DECISION DELEGATED TO DEVELOPMENT MANAGER

Application No: H16-1198-18 **Applicant:** Mr A Fragale
Proposal: Residential development (4 properties)
Location: Rear Of 11-13 Little London Spalding Lincs
Terminal Date: 4th March 2019

Title:
PROPOSED PLANS AND ELEVATIONS
PLOTS 1 & 2

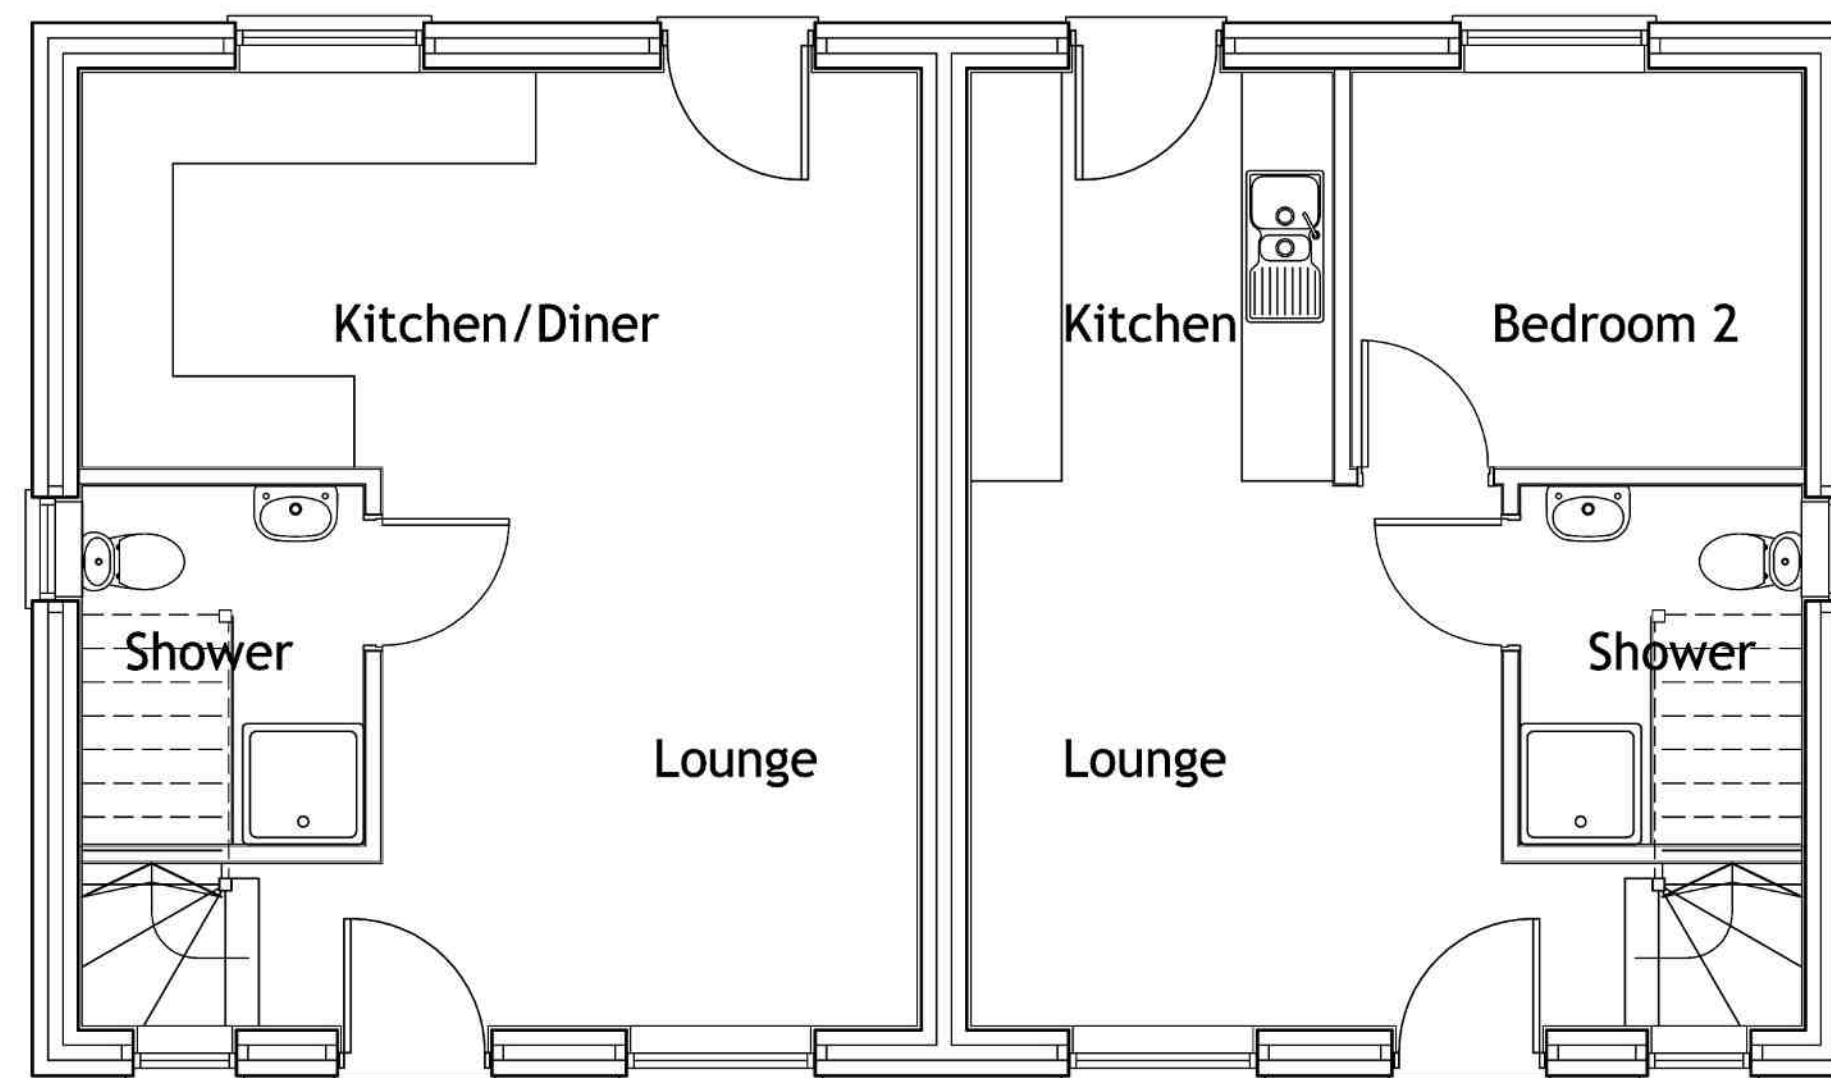
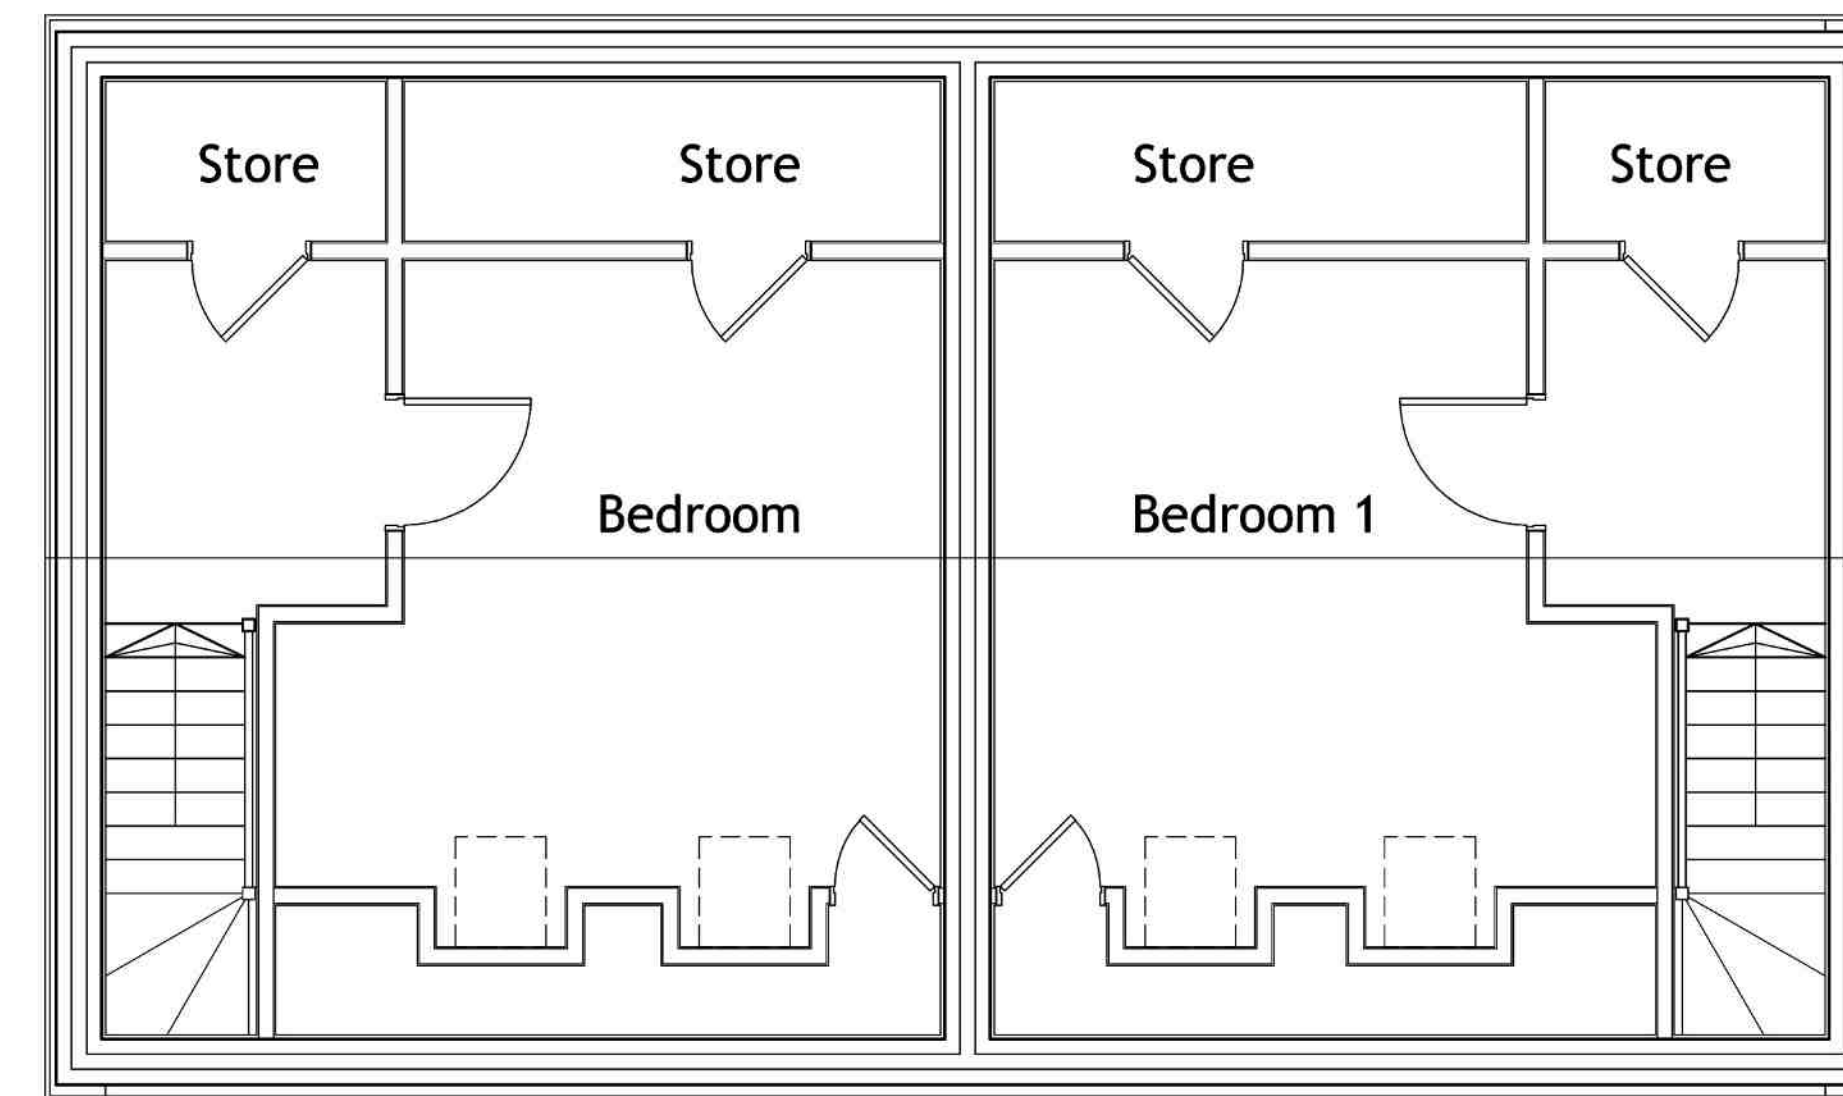
Concern was originally raised in relation to the potential for overlooking between the proposed dwellings and the properties to the front and the flats to the rear. There would only be a separation distance of approx. 12m to the frontage properties and approx. 15m to the flats behind. Consequently, amended plans have been received which show the rear windows of plots 1 and 2 as obscure glazed and the rooflights on the front elevation of all 4 plots as obscure glazed. Since submitting the application, the applicant has also installed windows with obscure glazing on the first floor facing windows of the properties to the front of the site. It is appreciated that there would still be the potential for occupants to open the windows in question, however given that the site is not location far from the town centre lesser separation distances are more acceptable and there are other examples of properties close together in the vicinity.
